From: Sue Howell
Sent: 11 June 2018 16:03
To: Planning.Responses
Cc: Anita Gardner
Subject: RE: Planning Consultation on: CM/7/18/PL

Comment from Greenspace

APPLICATION CM/7/18/PL

Description of Works: Change of use of land from agricultural field to 60 No. tent pitches operating from April to October to include 2 No. plumbed screened portable showers, 2 No. plumbed portable toilets, 2 No. screened changing cubicles, 2 No. 2 screened portable chemical toilets with hand wash facilities & washing up/drying area within existing building.

block plan 1:500@A2

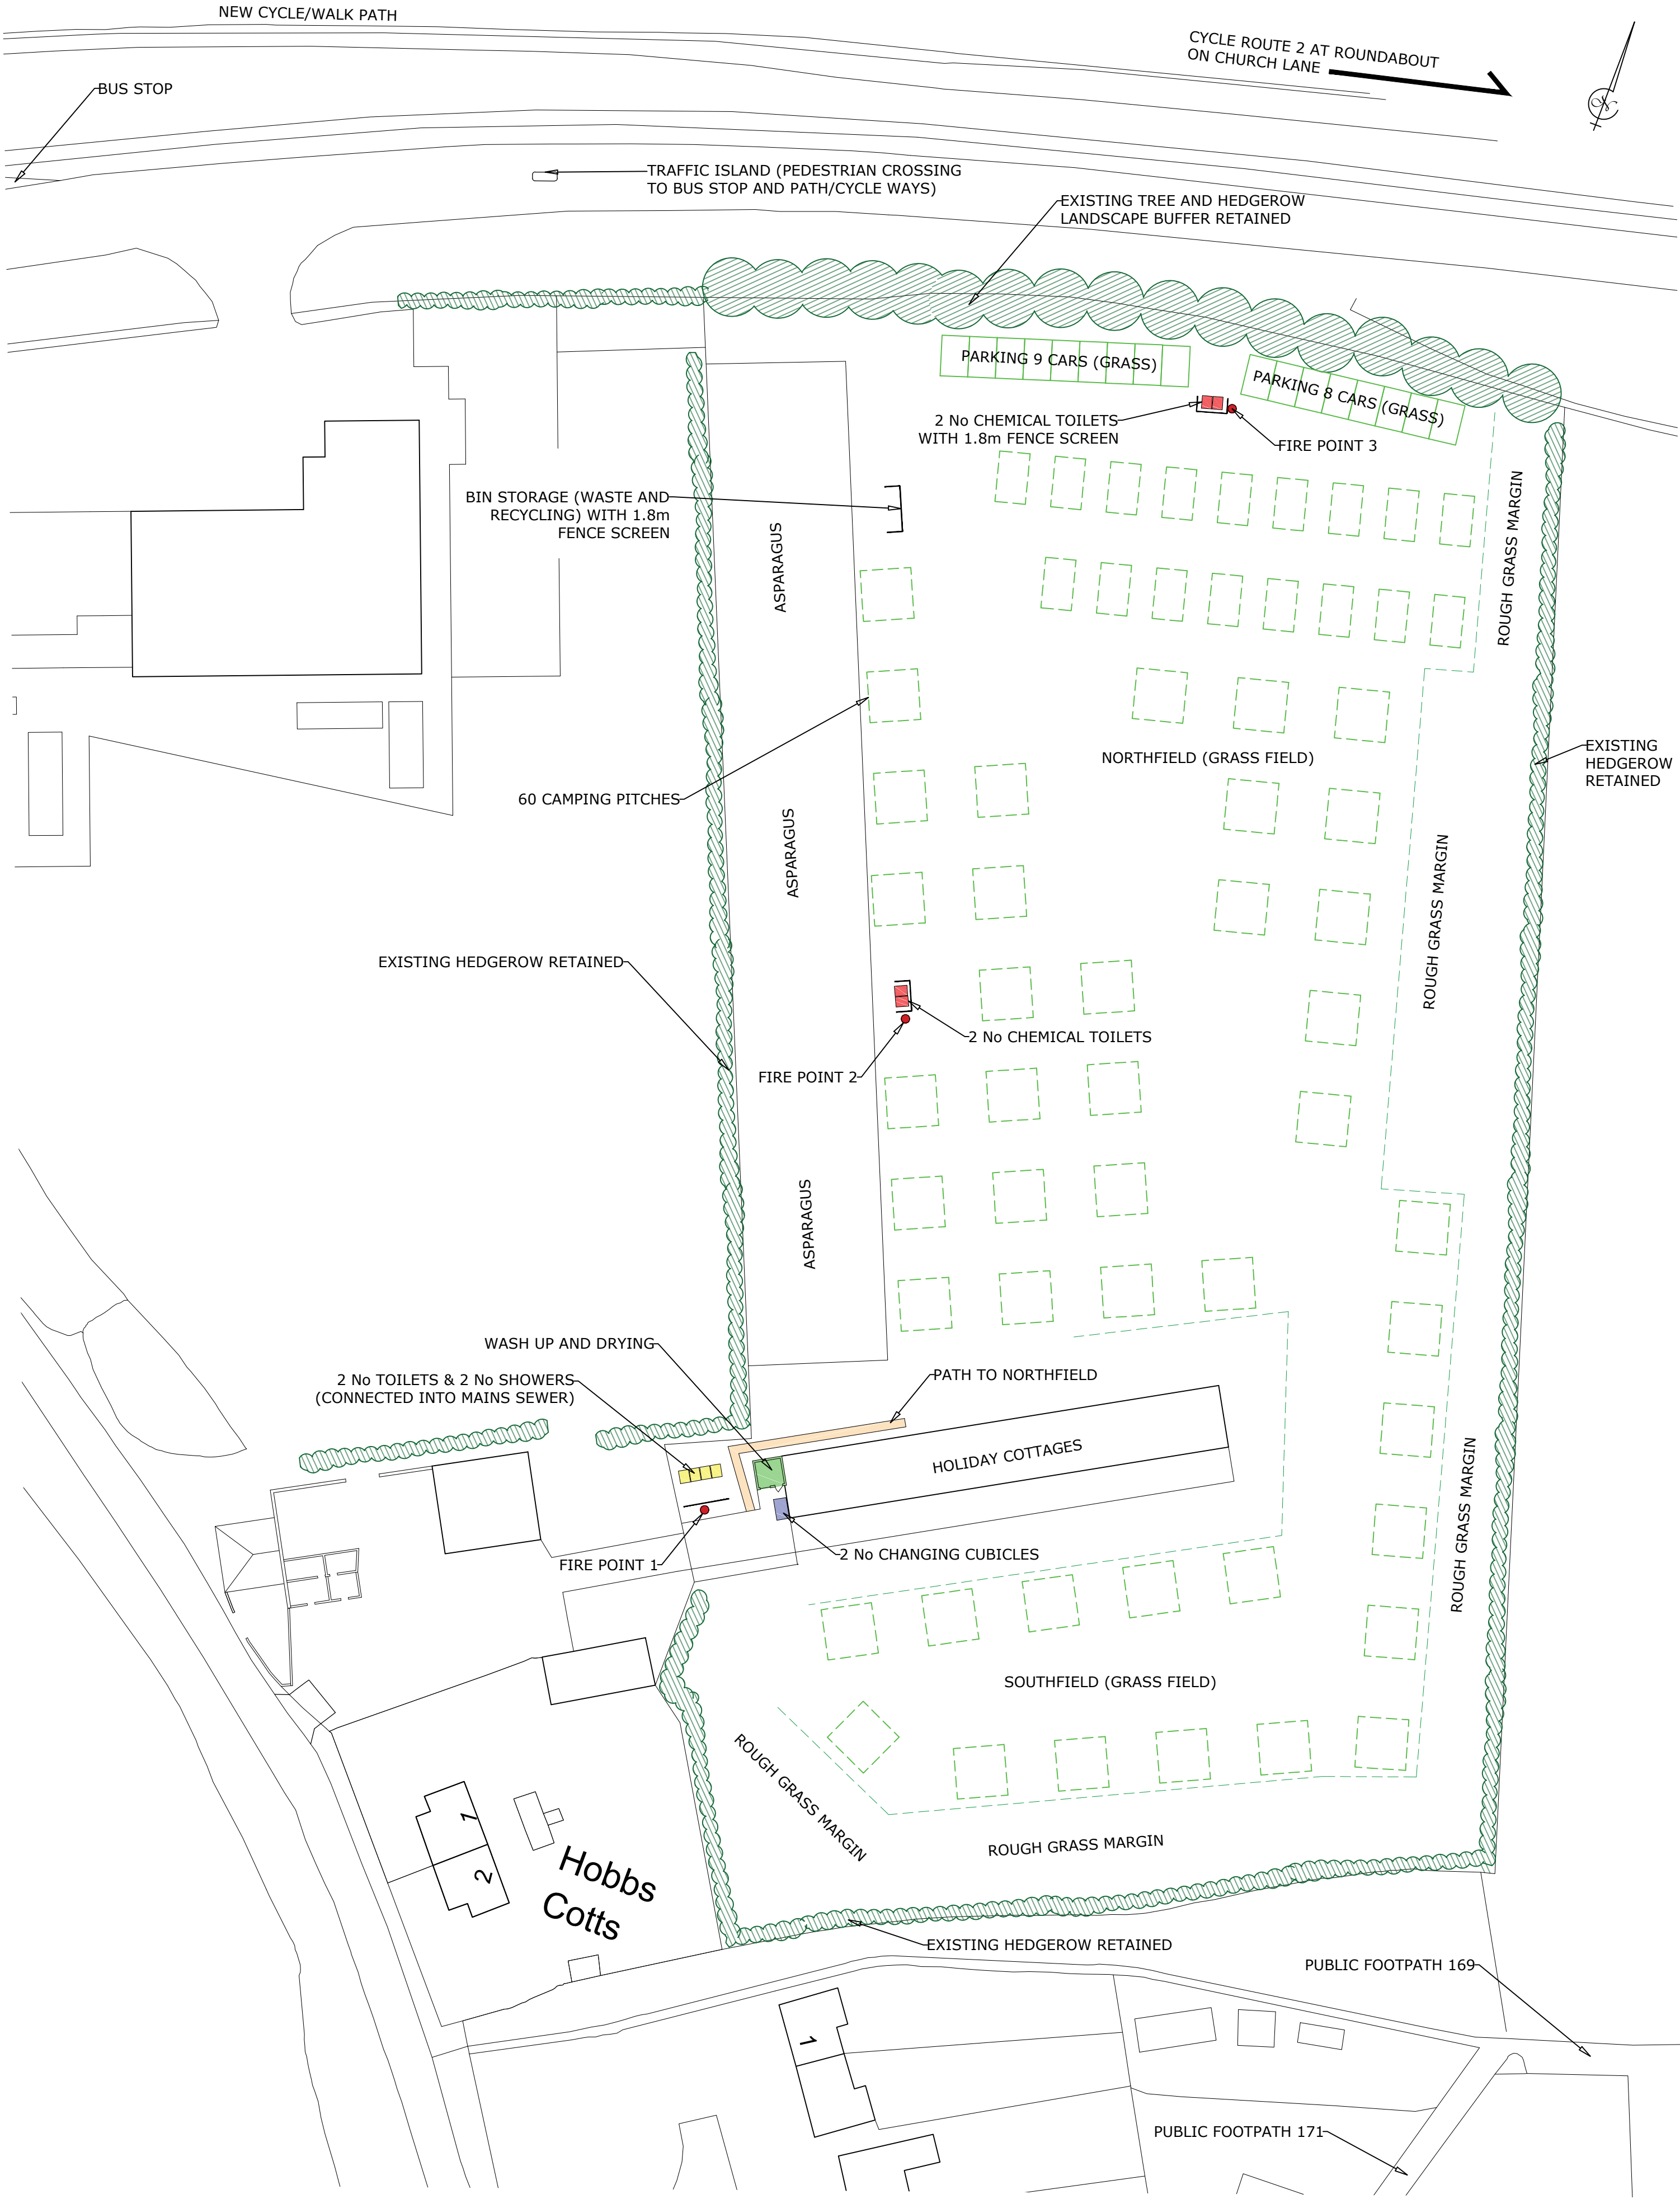
The indicative plan 1091/DPA02 indicates existing hedgerow to all sides of this proposed site including that bordering the open field to the East of the site. Confirmation would be sought in plan form to show detail of any existing and extent of any further gapping-up, mitigation screening works required.

Forming part of this application, a full landscape scheme should be submitted for approval, detailing species choice, position, densities and size at time of planting. This should be plotted in plan and list form and in relation to the trees and hedgerows to be retained so that a clear picture of the proposals can be seen. These details are required to ensure that appropriate screening is provided, maintaining and uncompromising the setting and ensuring that the proposals fit within the area of neighbouring properties and surrounds, whilst benefiting the potential of the proposed developments usage.
